FW: Planning Consultation on: WA/39/26/DOC

Application No: WA/39/26/DOC

Site Address: Longacres Eastergate Lane Walberton BN18 0BA

Description of Works: Approval of details reserved by condition imposed under WA/44/25/PL relating to conditions 3-surface water drainage and 4-discharge of flows to watercourses.

TREE PROTECTION PLAN

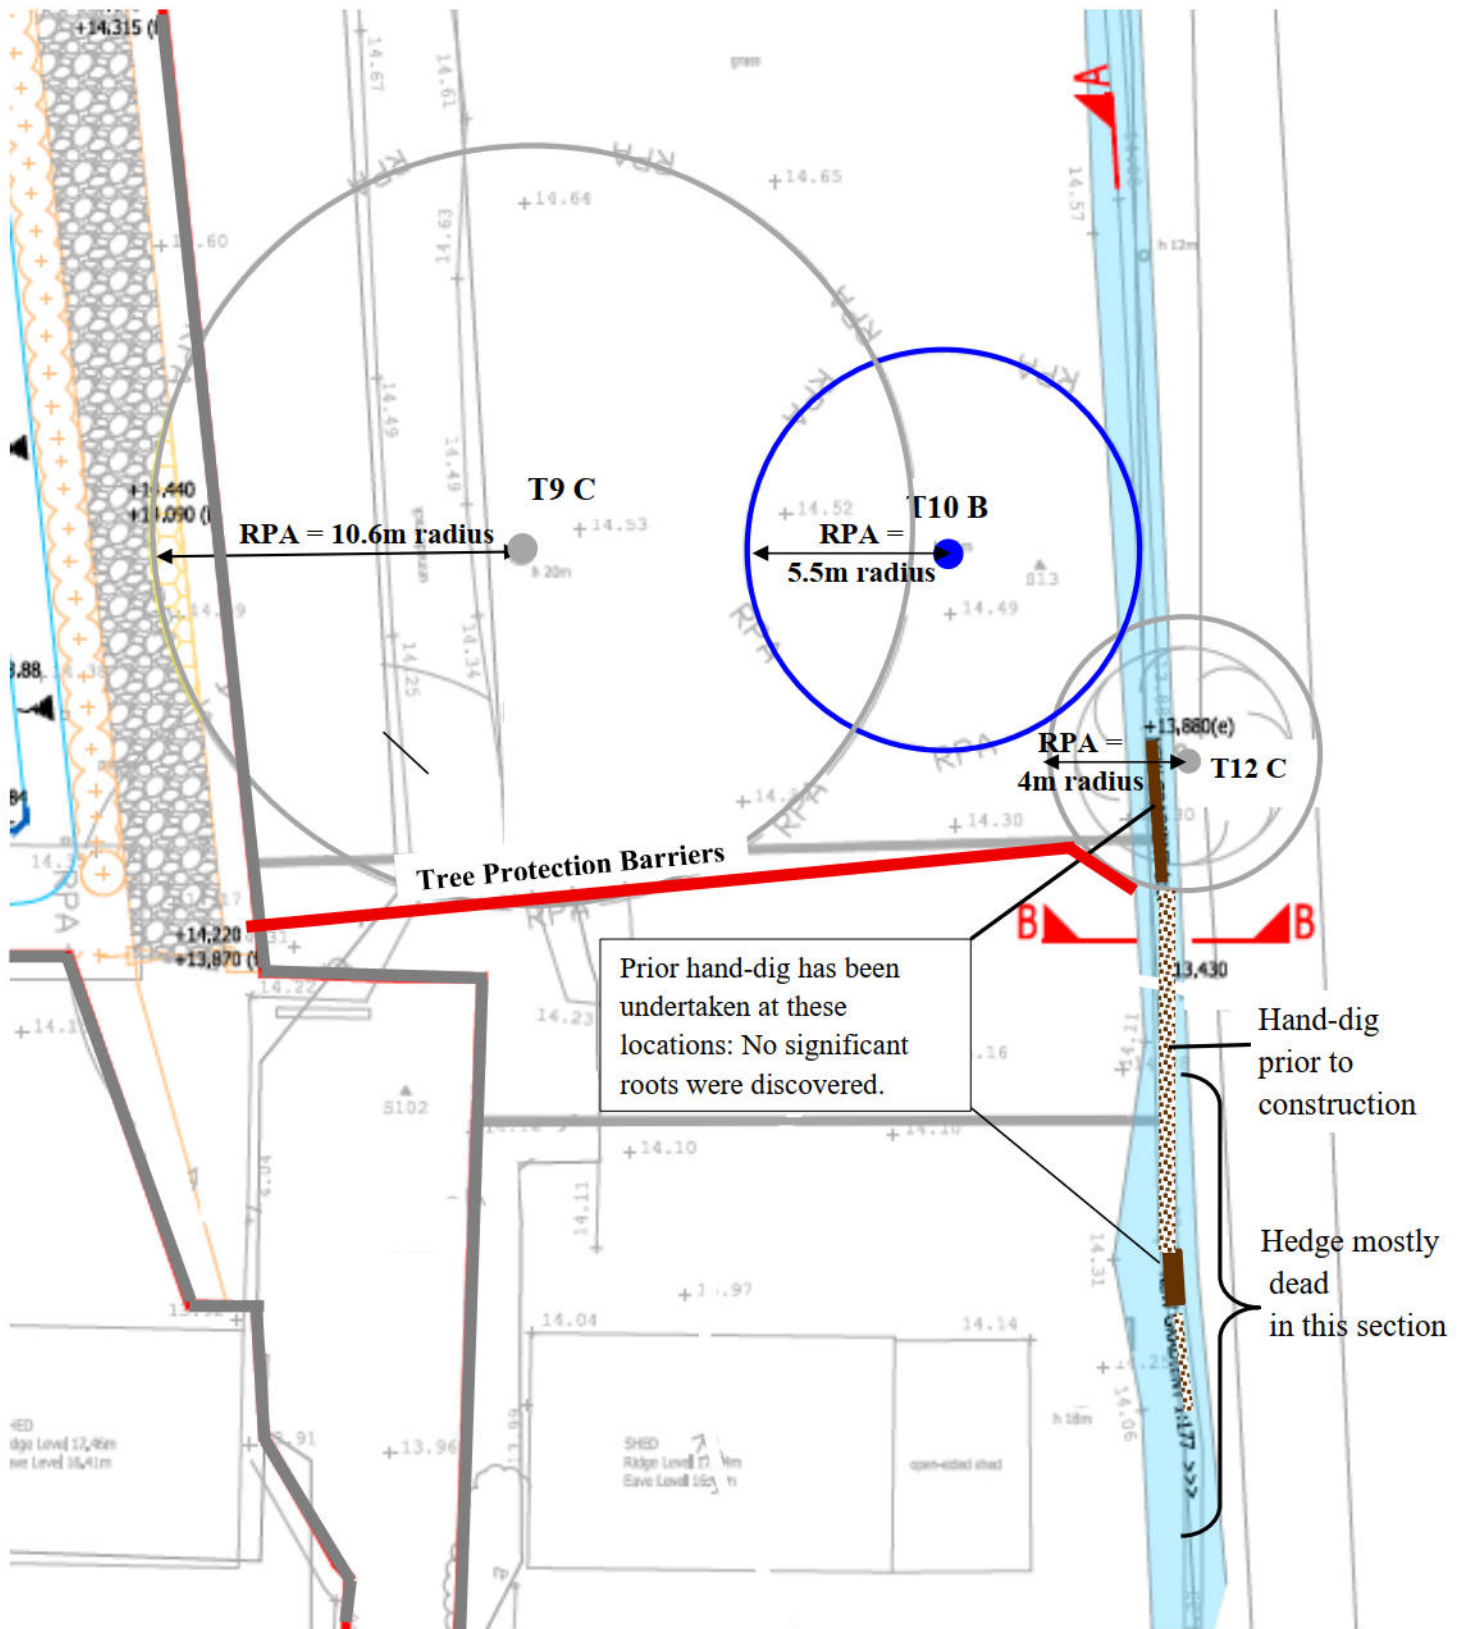
The report specifies that a tree protection fence must be installed for these works. Could we please ensure that the decision notes clarify that this fence is required *only* for the duration of the drainage installation on the neighbor's land? As no other works are planned for that area, it would be unnecessary to maintain the fencing for the entire build period.

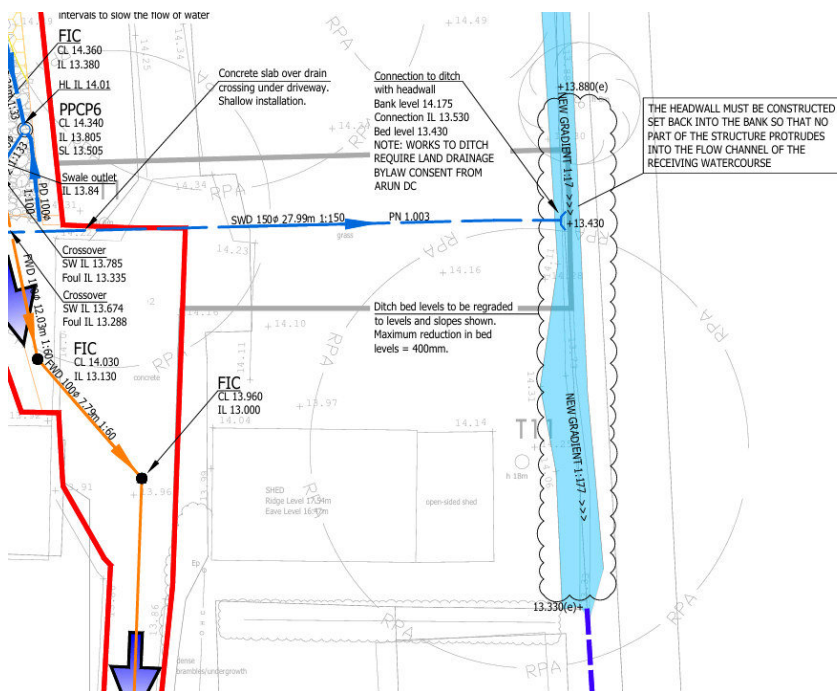
I am unclear which trees the Engineers have specific concerns with as it is a general comment, but as identified, it is clear to me that T11 would have been directly impacted. I would again, suggest that your Arboriculturist reviews the drainage plan, alongside the information concerning which trees are to be retained and those which are to be, or have been, removed, and provide a statement reviewing any impacts. If there are no longer any trees that would be impacted, a statement to this effect, alongside identification of which ones have been removed and why, would likely be sufficient.

The tree to the east of T10 also appears to be impacted along its margin. A point on this could be included within the statement.

Since this is a general comment from the Engineers, I would suggest you Arboriculturist reviews the drainage strategy proposed and comments on all trees that may be affected. However, the below is a snippet from your current drainage strategy. I think those directly impacted by levelling/excavation works within the ditch are the most crucial.

Just to provide an update: T11 was removed by the landowner last week for maintenance purposes, and the drainage works fall outside the RPA for T10. Our arborist is back this weekend, so we should be able to provide a formal comment next week. Knowing the specific tree of concern now will help us expedite the turnaround.
